RE: Ceja Vista Unit 1A, 1B, 1C, 2A, 2B, & C
Amended Drainage Management Plan
Stamp Date: 03/30/18
Hydrology File: P09D002E

Based upon the information provided in your submittal received 03/30/18, the Amended Drainage Management Plan **is not** approved for Grading Permit or action by the DRB on the Preliminary Plat. The following comments need to be addressed for approval of the above referenced project:

CEJA VISTA - UNIT 1
GRADING & DRAINAGE PLAN

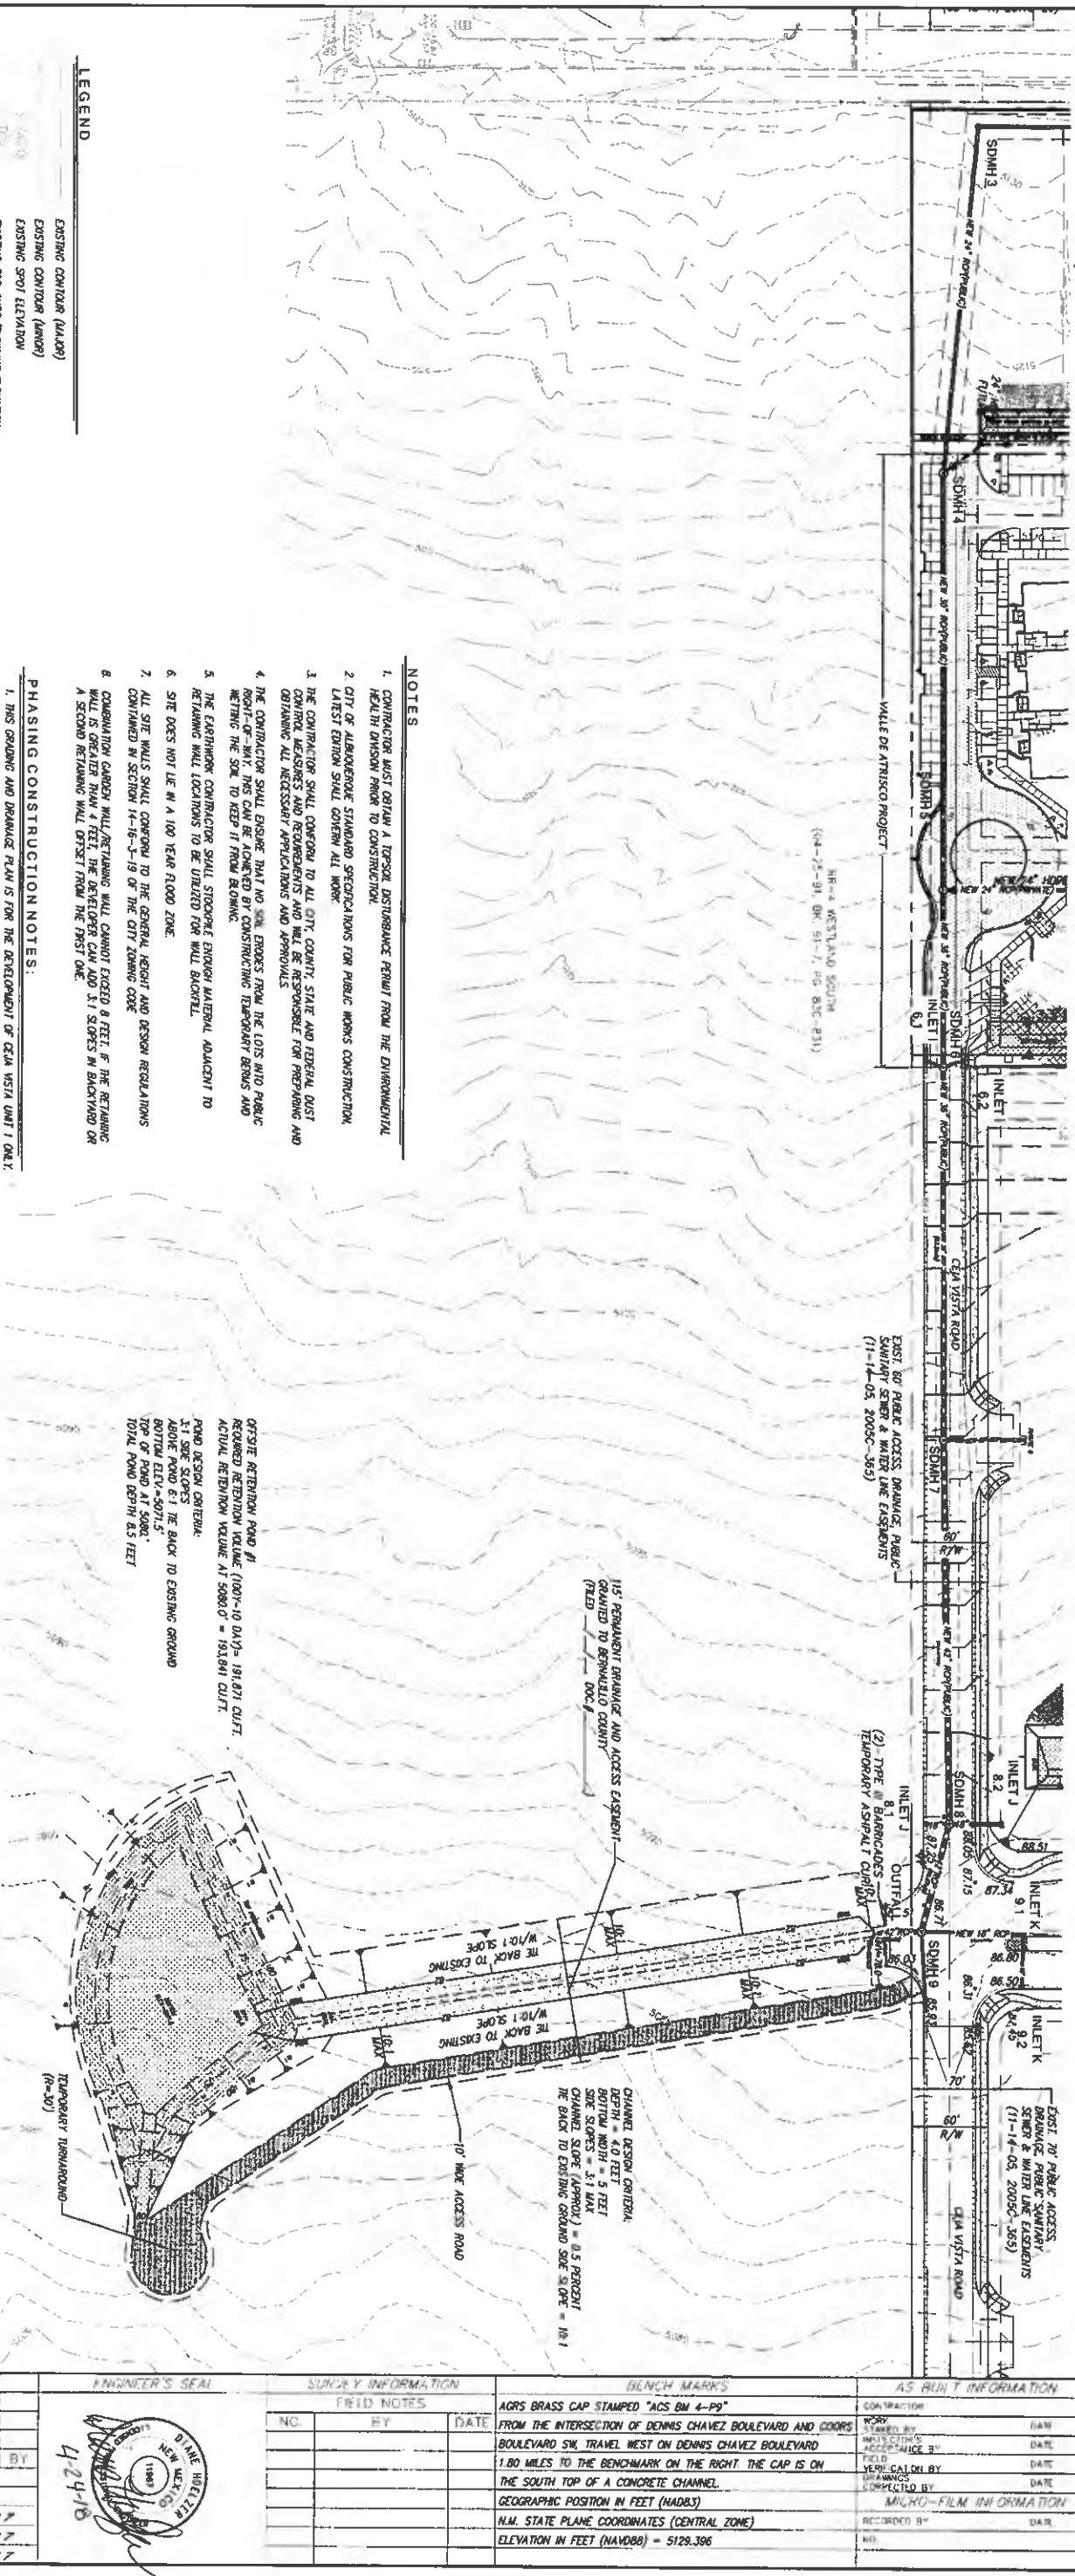
14. Grading and Drainage Plan Sheet 1. Please fix the vicinity map to include Tract RR-3-B, 98th street, and the offsite drainage channel & temporary retention pond within Bernalillo County.

15. Grading and Drainage Plan Sheet 1. Please label the diversion / temporary ponds on each Tract and in the calculation table.
16. Grading and Drainage Plan Sheet 1. Please connect each proposed diversion / temporary ponds to the proposed storm sewer stub outs.

17. Grading and Drainage Plan Sheet 1. Please add either a Private Cross Lot Drainage Easement at the southwest corner of Tract RR-3-A-2 for the pipe to Tract RR-3-A-1 or move the storm stub out from Tract RR-3-A-2 to Tract RR-3-A-1.

18. Grading and Drainage Plan Sheet 1. Please add a public turn-a-round at the end of Ceja Vista Road and provide grading for the turn-a-round.
19. Grading and Drainage Plan sheet 1. Please provide a section along Dennis Chavez showing the proposed ditch and show a trapezoidal section per the design calculation in the Amended Drainage Management Plan. Again maintenance must be accepted by NMDOT or change to curb and gutter.

20. Grading and Drainage Plan Sheet 1. Remove the arrows and label of "Valle de Atrisco Project". All work within Dennis Chavez will be done with this Grading and Drainage Plan.

21. Grading and Drainage Plan Sheet 1. Please show the proposed pavement returns for 98th Street at Dennis Chavez.
22. Grading and Drainage Plan Sheet 1. Please provide the 30 inch culvert inverts.
